**KIRKLEES METROPOLITAN COUNCIL
INVESTMENT & REGENERATION SERVICE**

**DELEGATED DECISION TO DETERMINE PLANNING APPLICATIONS TO
CARRY OUT DEVELOPMENT WITHOUT COMPLIANCE WITH PLANNING
CONDITIONS PREVIOUSLY ATTACHED**

Reference No: 2017/70/92557/W

Description: Variation condition 1 (plans) on previous permission
2016/93365 for reserved matters application pursuant
to outline permission 2014/91533 for erection of 30
dwellings

Location Plan
Scale 1:1250

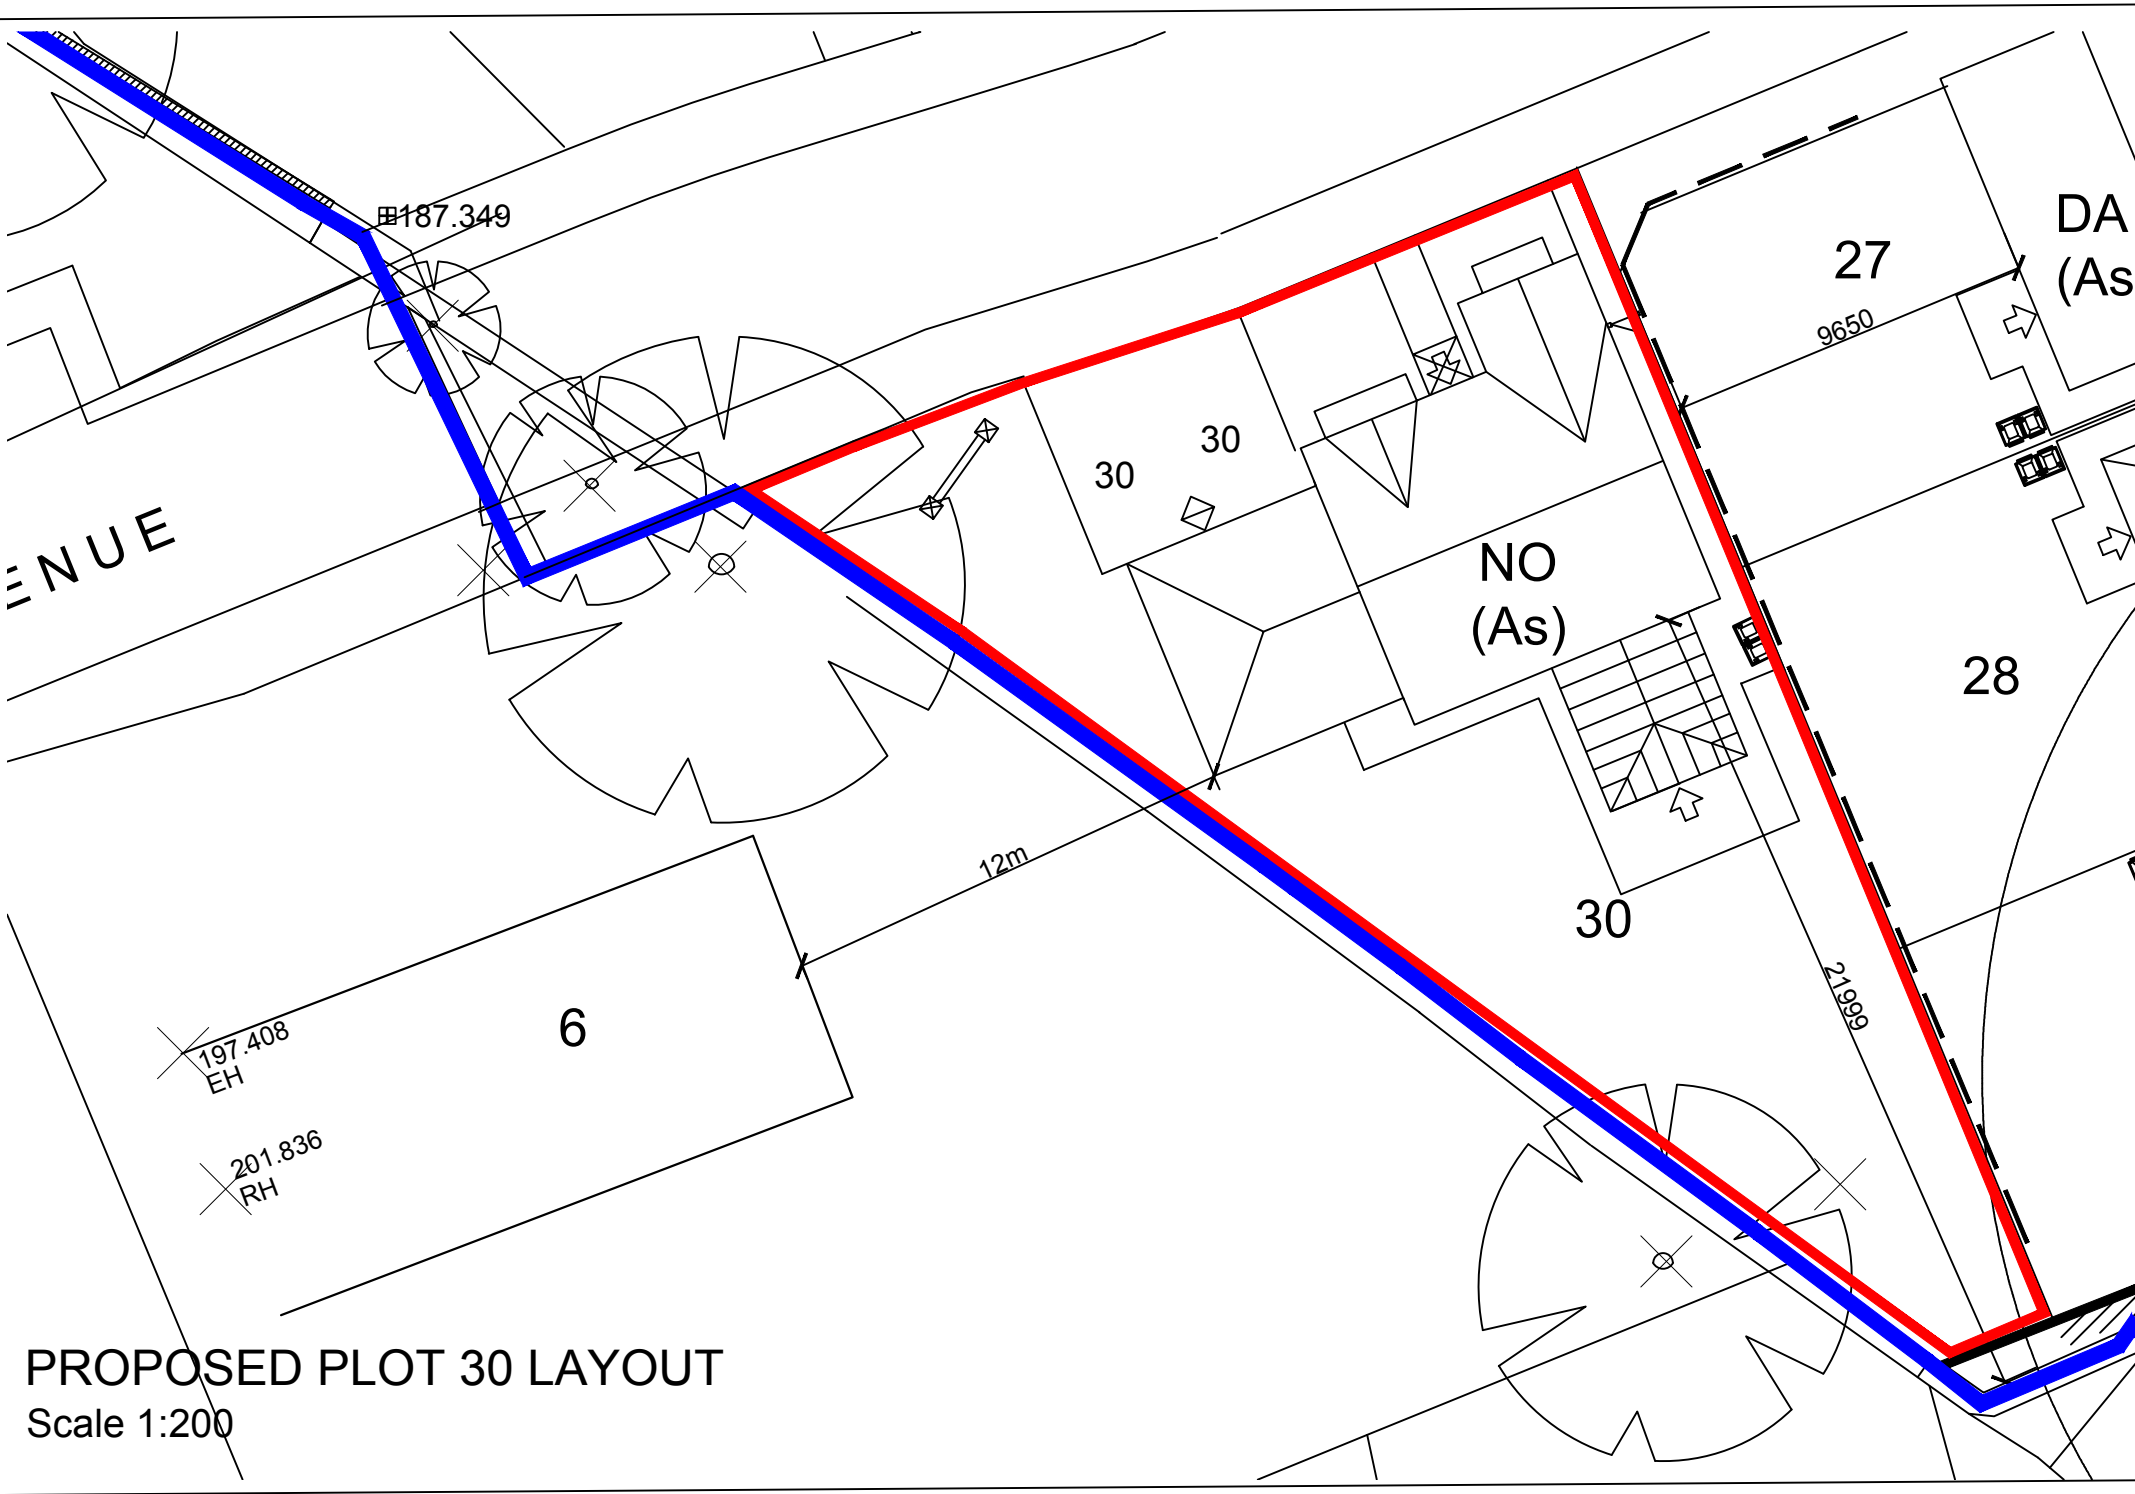
Plot 16: It is proposed to amend the house type from 'Styal' (4 bed) to 'Banbury' (4 bed). The reason for the proposed change is to accommodate the proposed surface water drainage strategy. The change repositions the dwellinghouse and reduces its footprint allowing for necessary stand-off distances to drainage infrastructure.

Officers have negotiated with the applicant an amendment to the proposed double garage on plot 30 to mitigate the impact on an adjacent existing property (6 St Mary's Ave).

- The double garage has been reduced in width by 0.55m to achieve 12m separation to the side elevation of 6 St Mary's Ave
- The garage roof has been hipped to reduce its massing

In addition, the developer has decided to re-orientate the conservatory doors towards the length of the garden rather than towards 6 St Mary's Ave to mitigate any potential privacy concerns.

The amendment to the proposed double garage has made it acceptable. The garage has been moved slightly further away from 6 St Mary's Avenue which enables it to comply with Policy BE12. The pitched roof of the garage has also been changed to a hipped roof which reduces the bulk and mass of the garage as perceived from the neighbouring property. It is to be noted as well that plot 30 is set down slightly from 6 St Mary's Avenue which also helps to mitigate the impact of the garage in these circumstances. Overall I am satisfied that the amenity of 6 St Mary's Avenue would not be significantly harmed by the change.

To accommodate the double garage the property has been moved 0.8m to the east. The position of plots 24, 27, 28 and 29 have also been revised to accommodate the larger plot for plot 30. The separation between plot 30 and plot 27 to the east remains acceptable, especially as this is a new dwelling to new dwelling relationship and no existing occupiers would be prejudiced in any way. The repositioning of plots 24, 27, 28 and 29 is very minor and do not result in any material impacts.
